Our Case Number: ABP-322242-25

Re: Proposed works at Bruree bridge, Co. Limerick.
Bruree bridge, Co. Limerick.

Re: Proposed works at Bruree bridge, Co. Limerick.
Bruree bridge, Co. Limerick.

Please be advised that the Commission, in accordance with section 177AE(5) of the Planning and Development Act, 2000, as amended, hereby requires you to furnish the following further information.

Figure 5. Drawing of planned repairs

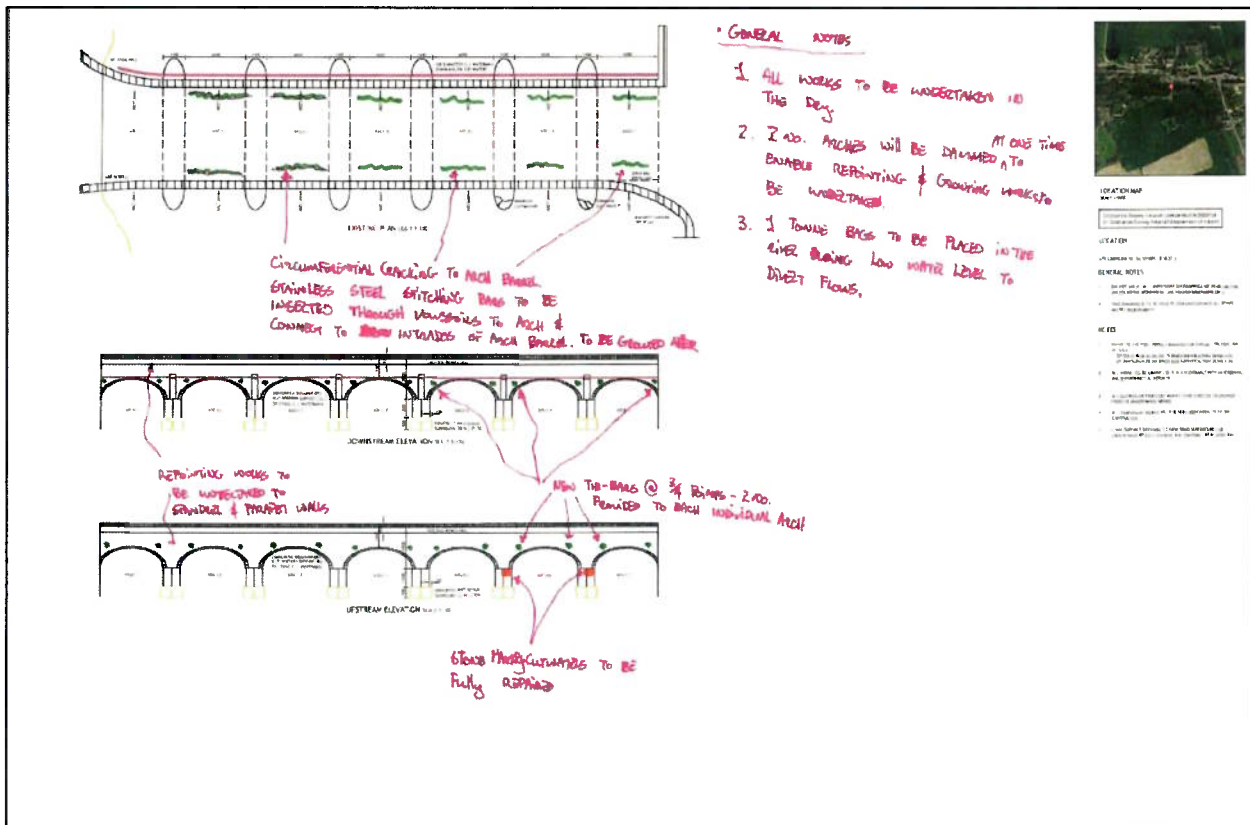
In addition, the applicant should note that it would be important that the proposed creation of dry cells under each arch sequentially does not prevent otter passage under the bridge at any time, even on a temporary basis. The resulting otter survey report should therefore include recommendations for this mitigation, following liaison with the works contractor.

DOWNSTREAM ELEVATION SCALE 1:100

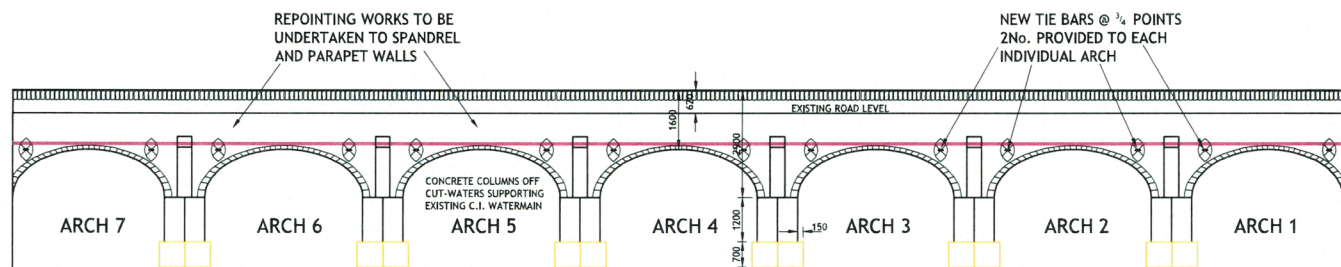
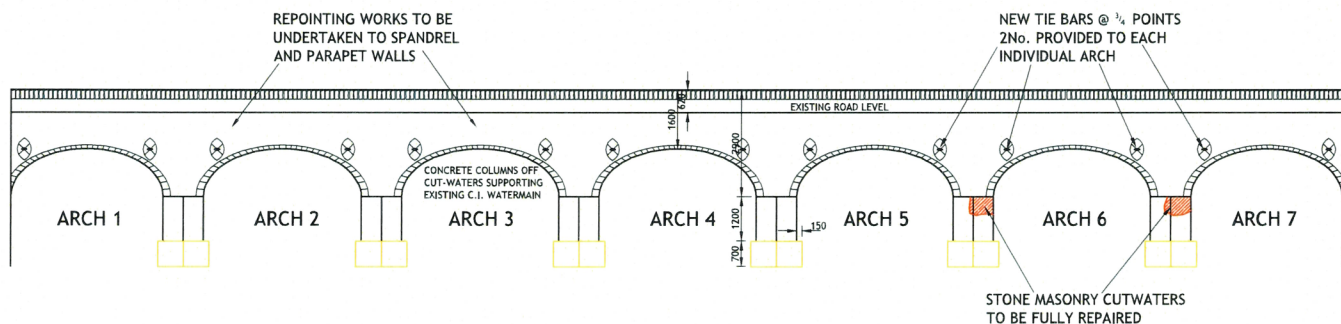
1. It is noted that Bruree Bridge is listed on the Record of Protected Structures (RPS) under the Limerick Development Plan 2022-2028 (RPS Reg. No. 1039), however no architectural heritage impact assessment/survey has been submitted with the application. In addition, it is noted that no method statement has been submitted.

- (a) An Architectural Heritage Impact Assessment Report completed by a suitably accredited architectural heritage professional to include:
 - (i) A full set of survey drawings to a scale of not less than [1:100] to include elevations, plans and sections of the structure;
 - (ii) the recording of the details and current condition;
 - (iii) confirmation that the development will be monitored by a suitably qualified architect with conservation expertise and accreditation; and
